Cottam Solar Project

Statement of Common Ground (~~DRAFT~~FINAL) Historic England

February 2024

Document reference: ~~EX1~~EX5/C8.3.4 A

Figure App.13.5-15:
ZTV from Thorpe medieval settlement
(NHLE 1016978)

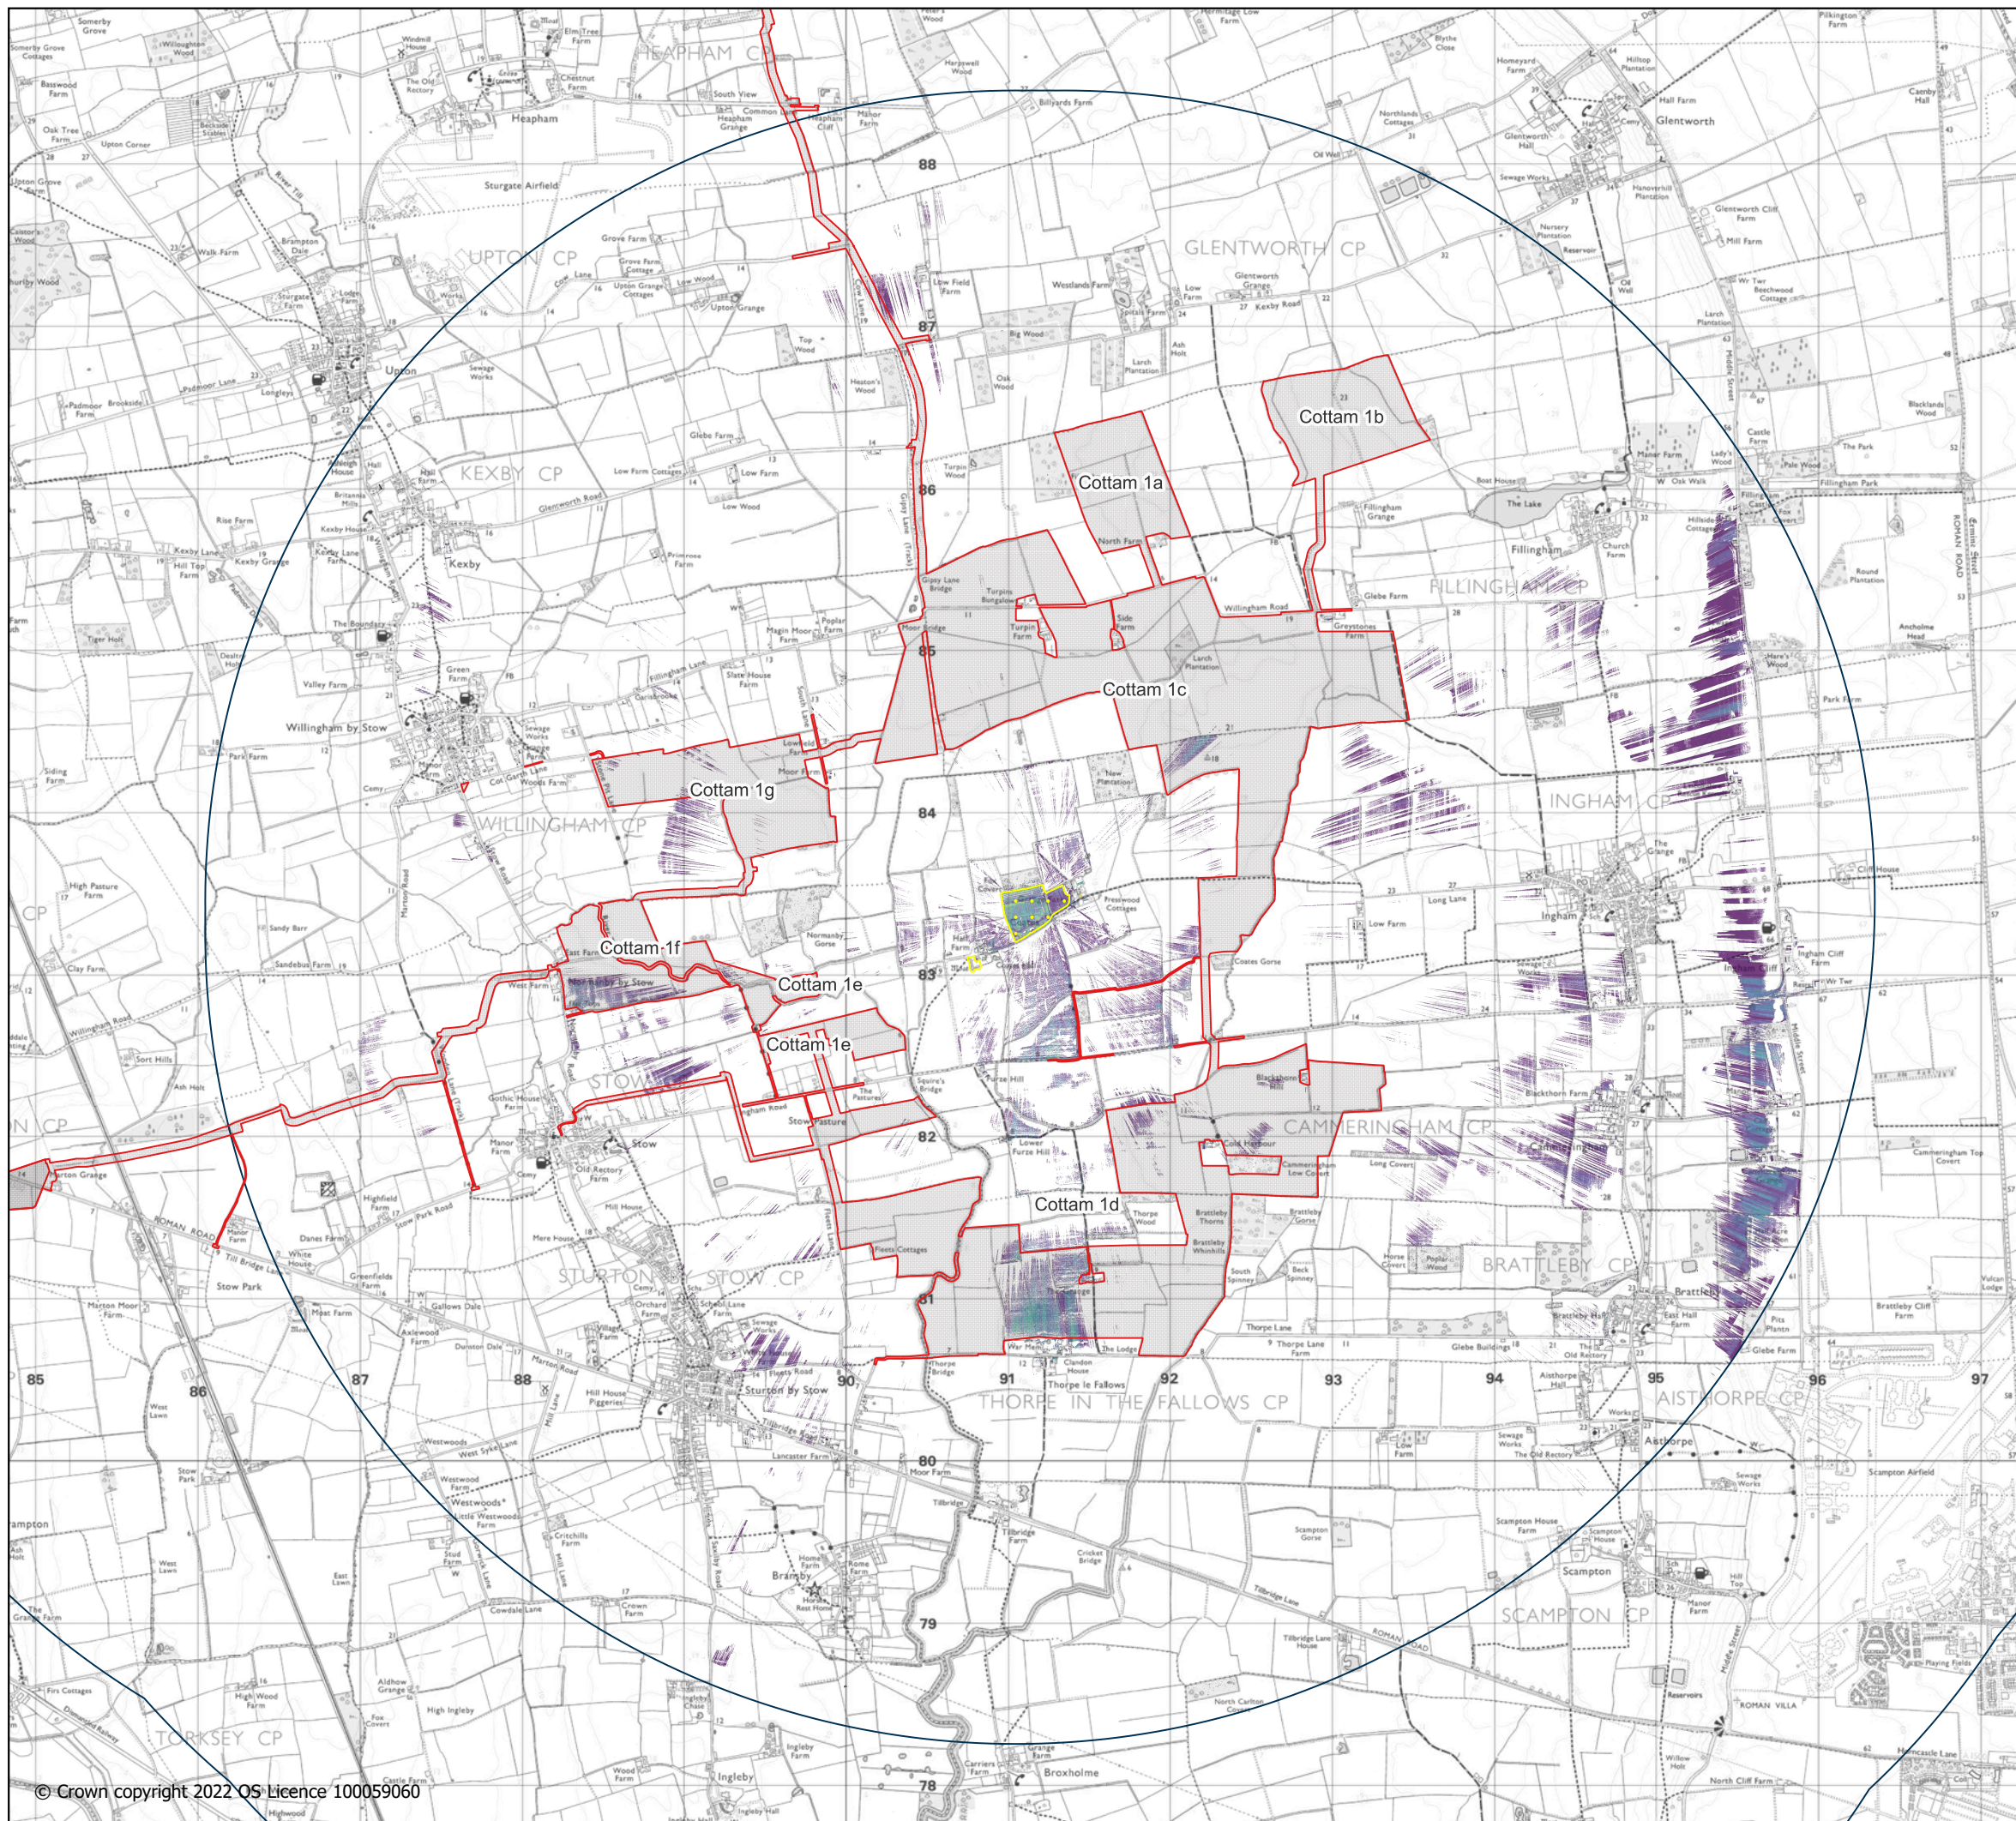
Topic	Sub-topic	Details of Matters Under Discussion
<p>HE-2</p> <p>Approach to safeguarding designated heritage assets</p>	<p>Scheduled Monument</p> <p>Thorpe medieval settlement (NHLE ref 1016978)</p>	<p>HE is in agreement with the Applicant that the potential impact of the Scheme on the setting of Scheduled Monument Thorpe medieval settlement (NHLE ref 1016978), as identified in ES Chapter 13 [EN010133/APP/C6.2.13], is 'moderate adverse' – 'significant', which equates to less than substantial harm using NPS/NPPF classification.</p> <p>To mitigate against any potential impacts to the setting of Thorpe medieval settlement (NHLE ref 1016978), and in response to comments by HE during a site visit on 13.05.2022, the proposed development has been offset c.50m from the northern edge of the Scheduled Monument. In addition, a hedgerow is proposed to be located to the north of Thorpe in the Fallows to provide screening between the village and the Scheme.</p> <p>HE considers the 50m buffer is insufficient and does not address the impacts caused by the Scheme to the significance of the monument. HE recommends that the panels are removed between the SMV and a former historic east-west boundary recorded on the 1886 25-inch Ordnance Survey (OS) map (approximately along the line of grid points: SK90976 80920, SK91149 80944, SK91330 80904 and SK91351 80909). The design of the Scheme should look to recreate the character of the former field boundary.</p> <p><i>"The historic agrarian setting of the Thorpe le Fallows scheduled monument is important to its significance as the remains of a rural medieval settlement. Further to our rejection of the proposed c50m offset as insufficient to address the setting of the monument, we have advised that this specific field boundary should be reinstated as a limit to the solar array. This former boundary has a direct historic landscape relationship to the shrunken</i></p>

<p><i>settlement remains to its south and the rising round upon which Thorpe le Fallows sits. The irregular line of this east-west boundary as shown on the 1st edition OS 1:2500 mapping suggests it sat in an organic relationship to the pattern of open field cultivation stripes and associated land tenure, in contrast to the straighter more regular subdivision of strips characteristic of more structured enclosure. The significance of the monument is not set in a singular medieval moment of fully open fields and peak population that can be juxtaposed to an equally static post-medieval landscape of depopulation and enclosure. Central to the understanding and appreciation of shrunken or deserted medieval villages is that the archaeological remains we encounter relate to complex and extended processes of social and economic change; sudden changes may occur but they do not define the limit of interest or understanding. Significance is therefore [diachronic] concerned with the history and evolution of the monument in this landscape rather than [synchronic] confined to certain particular points in time. We have set out a reasonable measure to conserve and better reveal the significance of the scheduled monument, and reframe it in the context of the harm resulting from development's transformation of its agrarian setting. The reinstatement of this former boundary as a limit to the solar array is both proportionate and necessary to a sustainable planning outcome. The irregular character of the boundary is important to the effectiveness of this mitigation, any functional straight line security fencing would need therefore to sit north of the reinstated boundary. To be effective as mitigation the reinstated boundary would need to be a laid hedgerow and would benefit from the inclusion of some standard trees for instance crab apple, field maple etc."</i></p> <p>Although the Applicant appreciates HE's position that the former east-west field boundary to the north of the village is a vital aspect of the evolution of the landscape to the north of the village and so helps create a structured relationship between the of the village and its immediate hinterland, with respect to the transitional historic character of Thorpe in the Fallows (meeting dated 22.06.2023), the Applicant believes that the east-west field boundary quintessentially belongs to a post-medieval to early modern landscape characterised by small enclosed fields, which is in direct contrast to</p>

Topic	Sub-topic	Details of Matters Not Agreed
<p><u>HE-2</u> <u>Approach to safeguarding designated heritage assets</u></p>	<p><u>Scheduled Monument Thorpe medieval settlement (NHLE ref 1016978)</u></p>	<p><u>HE and the Applicant are not in agreement as to appropriate mitigation of setting impacts upon the significance of Thorpe medieval settlement, a scheduled monument.</u></p> <p><u>HE is in agreement with the Applicant that the potential impact of the Scheme on the setting of Scheduled Monument Thorpe medieval settlement (NHLE ref 1016978), as identified in ES Chapter 13 [APP-048], is 'moderate adverse' – 'significant', which equates to less than substantial harm using NPS/NPPF classification.</u></p> <p><u>To mitigate against any potential impacts to the setting of Thorpe medieval settlement (NHLE ref 1016978), and in response to comments by HE during a site visit on 13.05.2022, the proposed development has been offset c.50m from the northern edge of the Scheduled Monument. In addition, a hedgerow is proposed to be located to the north of Thorpe in the Fallows to provide screening between the village and the Scheme.</u></p> <p><u>HE considers the 50m buffer is insufficient and does not address the impacts caused by the Scheme to the significance of the monument. HE recommends that the panels are removed between the SMV and a former historic east-west boundary recorded on the 1886 25-inch Ordnance Survey (OS) map (approximately along the line of grid points: SK90976 80920, SK91149 80944, SK91330 80904 and SK91351 80909). The design of the Scheme should look to recreate the character of the former field boundary. HE has stated the following:</u></p>

<p><i><u>“The historic agrarian setting of the Thorpe le Fallows scheduled monument is important to its significance as the remains of a rural medieval settlement. Further to our rejection of the proposed c50m offset as insufficient to address the setting of the monument, we have advised that this specific field boundary should be reinstated as a limit to the solar array. This former boundary has a direct historic landscape relationship to the shrunken settlement remains to its south and the rising round upon which Thorpe le Fallows sits. The irregular line of this east-west boundary as shown on the 1st edition OS 1:2500 mapping suggests it sat in an organic relationship to the pattern of open-field cultivation stripes and associated land tenure, in contrast to the straighter more regular subdivision of strips characteristic of more structured enclosure. The significance of the monument is not set in a singular medieval moment of fully open fields and peak population that can be juxtaposed to an equally static post-medieval landscape of depopulation and enclosure. Central to the understanding and appreciation of shrunken or deserted medieval villages is that the archaeological remains we encounter relate to complex and extended processes of social and economic change; sudden changes may occur but they do not define the limit of interest or understanding. Significance is therefore [diachronic] concerned with the history and evolution of the monument in this landscape rather than [synchronic] confined to certain particular points in time. We have set out a reasonable measure to conserve and better reveal the significance of the scheduled monument, and reframe it in the context of the harm resulting from development’s transformation of its agrarian setting. The reinstatement of this former boundary as a limit to the solar array is both proportionate and necessary to a sustainable planning outcome. The irregular character of the boundary is important to the effectiveness of this mitigation, any functional straight-line security fencing would need therefore to sit north of the reinstated boundary. To be effective as mitigation the reinstated boundary would need to be a laid hedgerow and would benefit from the inclusion of some standard trees for instance crab apple, field maple etc.”</u></i></p> <p><u>Although the Applicant appreciates HE’s position that the former east-west field boundary to the north of the village is a vital aspect of the evolution of the landscape to</u></p>

<p>the medieval landscape which was formed by large open field systems. The scheduling of the Thorpe in the Fallows SMV pertains only to the medieval village, and so as such does not relate to the later post-medieval landscape. Therefore, the Applicant respectfully disagrees with the deduction that the former east-west field boundary contributes to the significance of the scheduled SMV, and that removing solar panels between the SMV and the field boundary would enhance the experience of the heritage asset/reduce impact.</p>
--	--	--

<p><u>the north of the village and so helps create a structured relationship between the of the village and it immediate hinterland, with respect to the transitional historic character of Thorpe in the Fallows (meeting dated 22.06.2023), the Applicant considers that the east-west field boundary quintessentially belongs to a post-medieval to early modern landscape characterised by small enclosed fields, which is in direct contrast to the medieval landscape which was formed by large open field systems. The scheduling of the Thorpe in the Fallows SMV pertains only to the medieval village, and so as such does not relate to the later post-medieval landscape. Therefore, the Applicant respectfully disagrees with the deduction that the former east-west field boundary contributes to the significance of the scheduled SMV, and that removing solar panels between the SMV and the field boundary would enhance the experience of the heritage asset/reduce impact. Further information detailing the Applicant's position can be found in the Applicant's Response to ExA First Written Questions (Response 1.9.9) [REP2-034], Written Summary of Applicant's Oral Submissions and Responses to Action Points at Issue Specific Hearing 2 (Agenda Item 3A) [REP3-033] and Applicant's Responses to Deadline 3A and 4 Submissions (Response 2.9.2) [EN010133/EX5/C8.1.32].</u></p> <p><u>The Applicant has calculated that the removal of the solar panels between the Thorpe medieval settlement SM and the former field boundary, as recommended by HE, would result in the loss of approximately 4.725 MWp of installed capacity and 5.5 MWh/year energy generation loss, based upon the indicative layouts that the Environmental Statement was based upon. The Applicant does however note that this figure is subject to change dependent upon future advances in technology which could increase the generating efficiency of panels.</u></p>
